CUMBERLAND
CITY COUNCIL

Ref: OA2021/0010
DPIE Ref: SSD-19425495

25 October 2022

Subject: Request for Comments - State Significant Development (SSD)
Application No: SSD-19425495
Property: 132-144 Warren Road SMITHFIELD NSW 2164
Lot 2 DP 1230452
Proposal: Use of an existing warehouse (operating 24 hours 7 days a week) to receive up to 150,000 tonnes per annum of domestic and commercial recyclable materials and sort these materials into categories (ferrous metals, non-ferrous metals, glass, plastics, paper and cardboard, and residual) for transportation to dedicated reprocessing facilities.

Ref:	Scale: NTS
File name 20220808 SMF_MRF_GA_DWG200 LH	SHEET PAGE 1 OF 5
SMITHFIELD MRF	
Note: SITE OVERVIEW	Revision 12

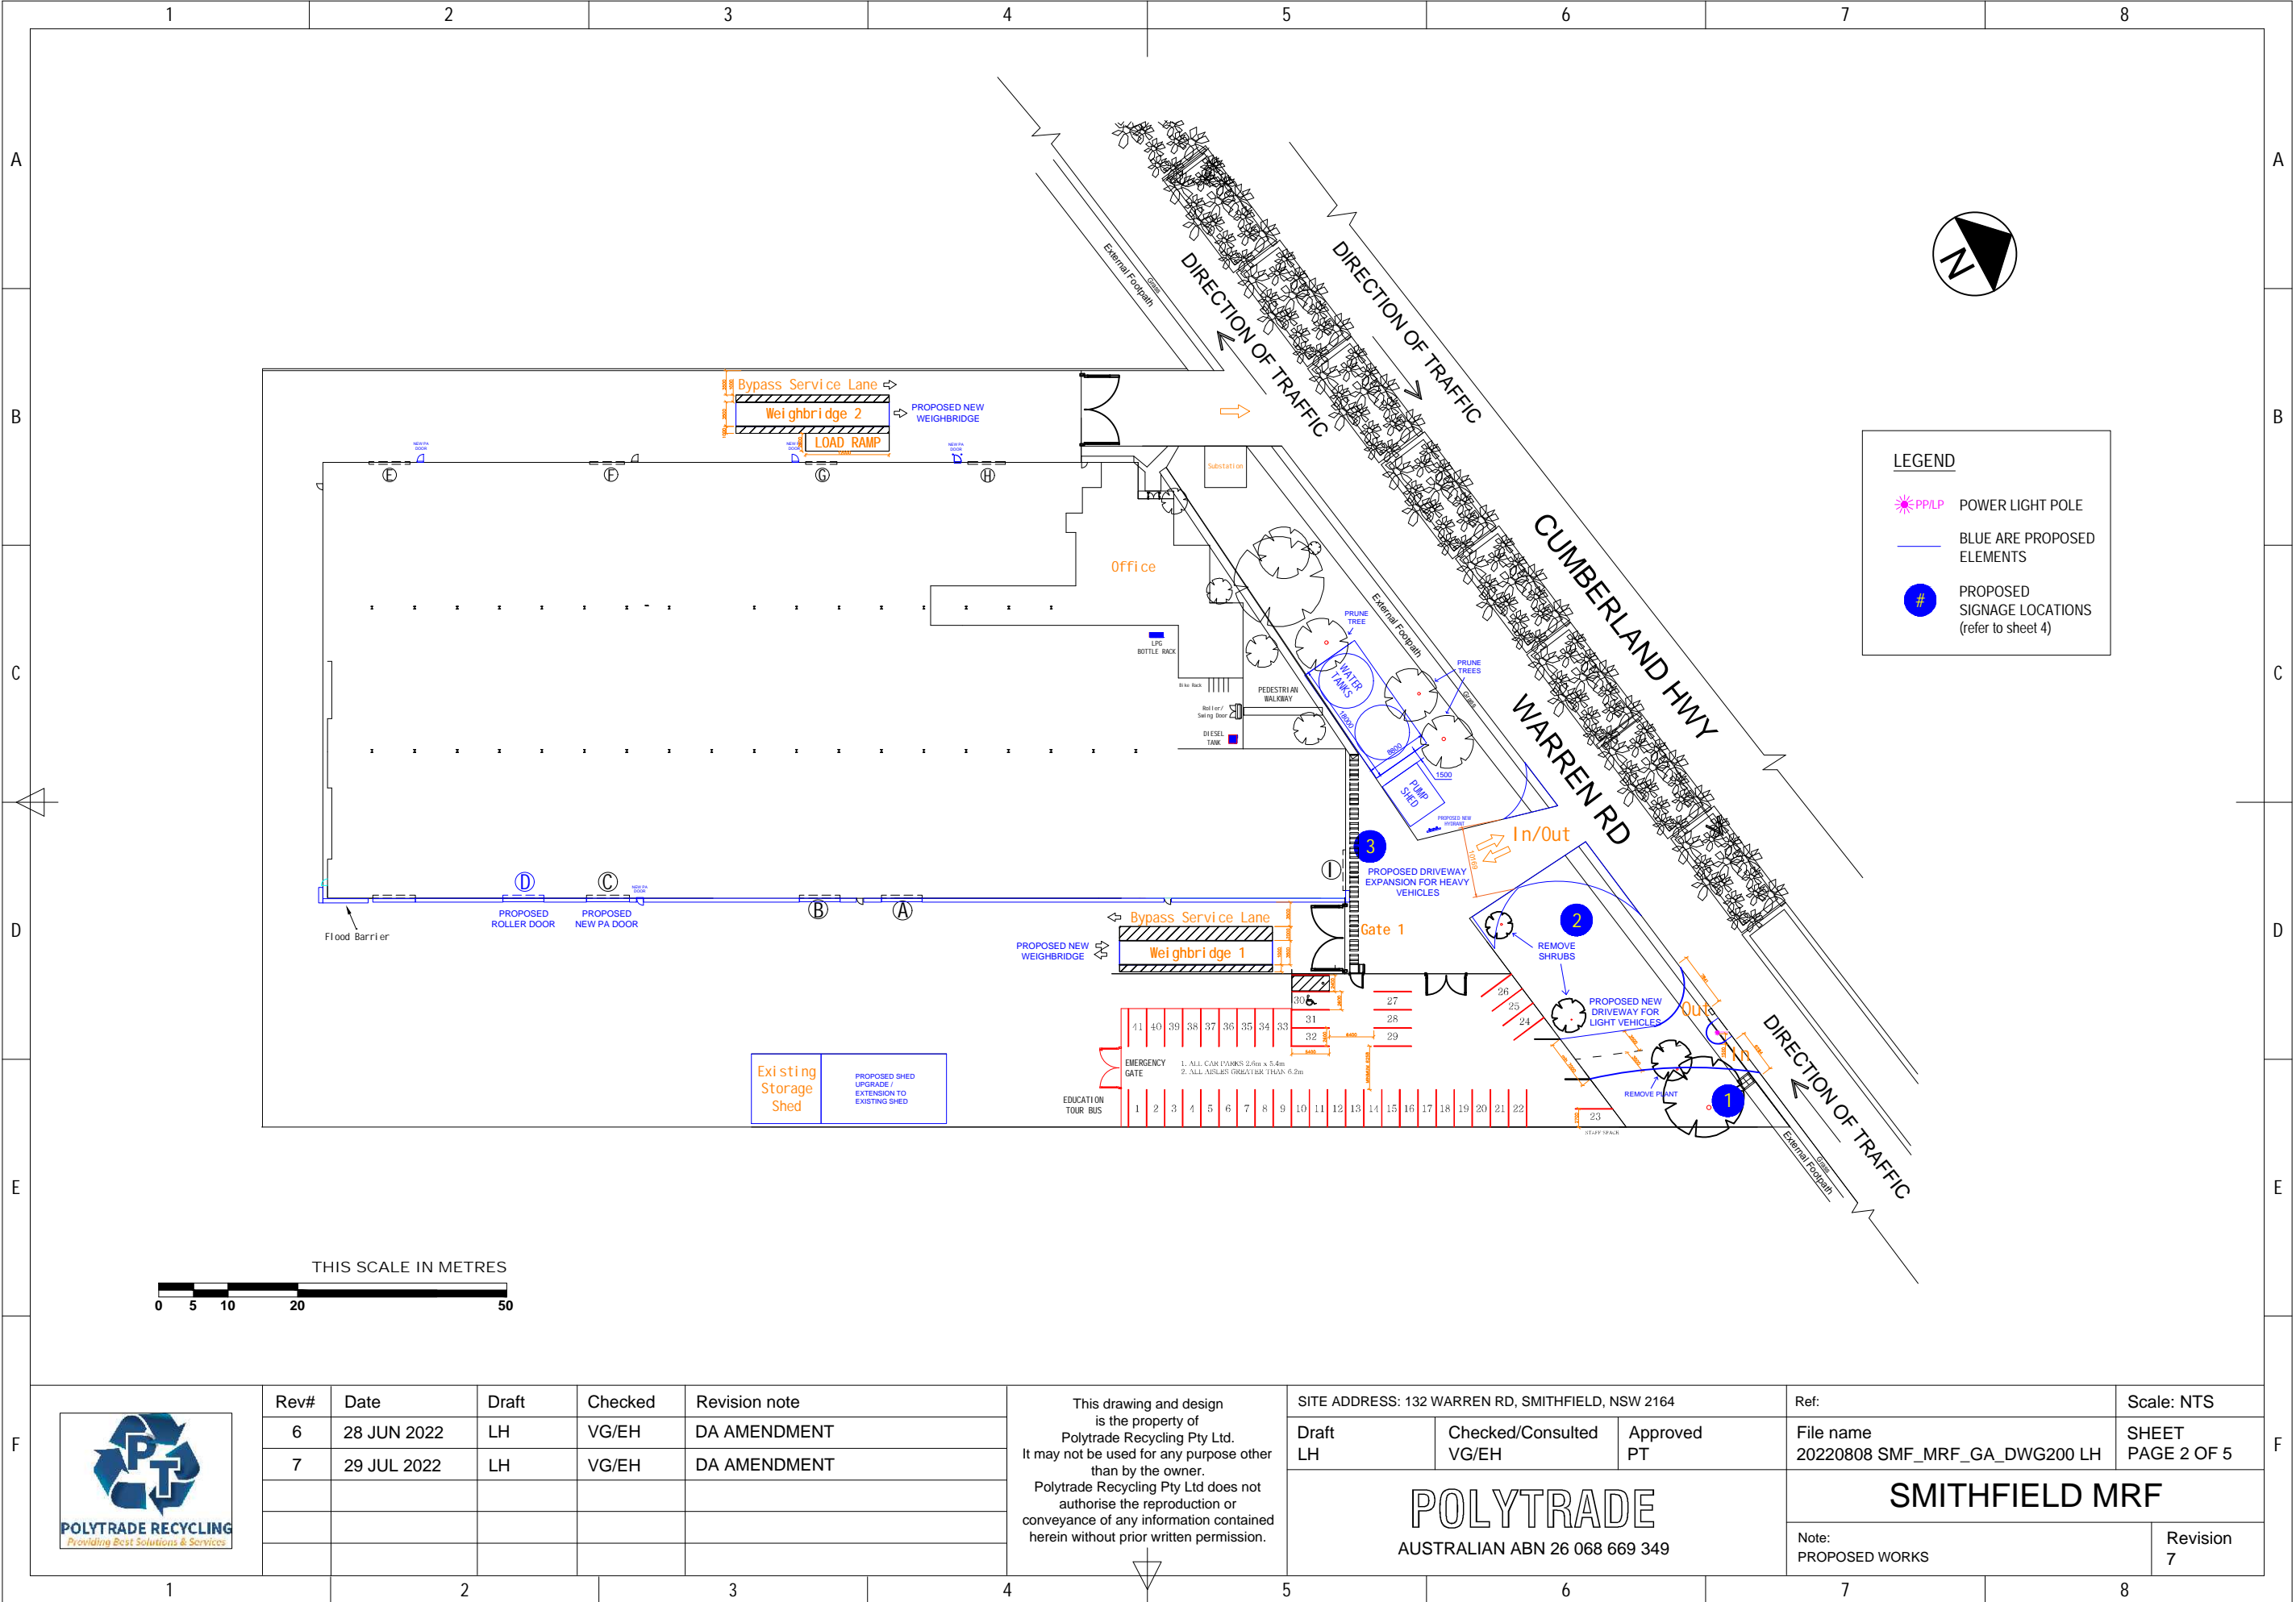
- a. Proposed stormwater works extends outside the subject development site. Stormwater easement is required for any works outside the subject site. No details provided with the subject application.

- b. The Council's stormwater pipe along the western boundary appears to be incorrect. Exact location of the Council's pipe within the subject site shall be located by service search and annotated on the plans. Service search details shall be submitted. Any modification to Council's pipe drainage system shall be discussed with Council's Stormwater Engineer.

- d. The stormwater works conflicts with the existing easements. In this regard, appropriate approvals shall be required for the proposed works. Detail service search shall be submitted to ensure proposed stormwater design does not conflict with any existing services within the easements.

- a. The number of vehicular accesses shall be limited to improve the pedestrian safety. In this regard, proposed carpark access shall be provided through the existing eastern driveway.

- c. Gate 1 and Gate 2 driveway widths are not adequate for the simultaneous entry/exit of the trucks. In this regard, single entry/exit driveway option shall be considered.
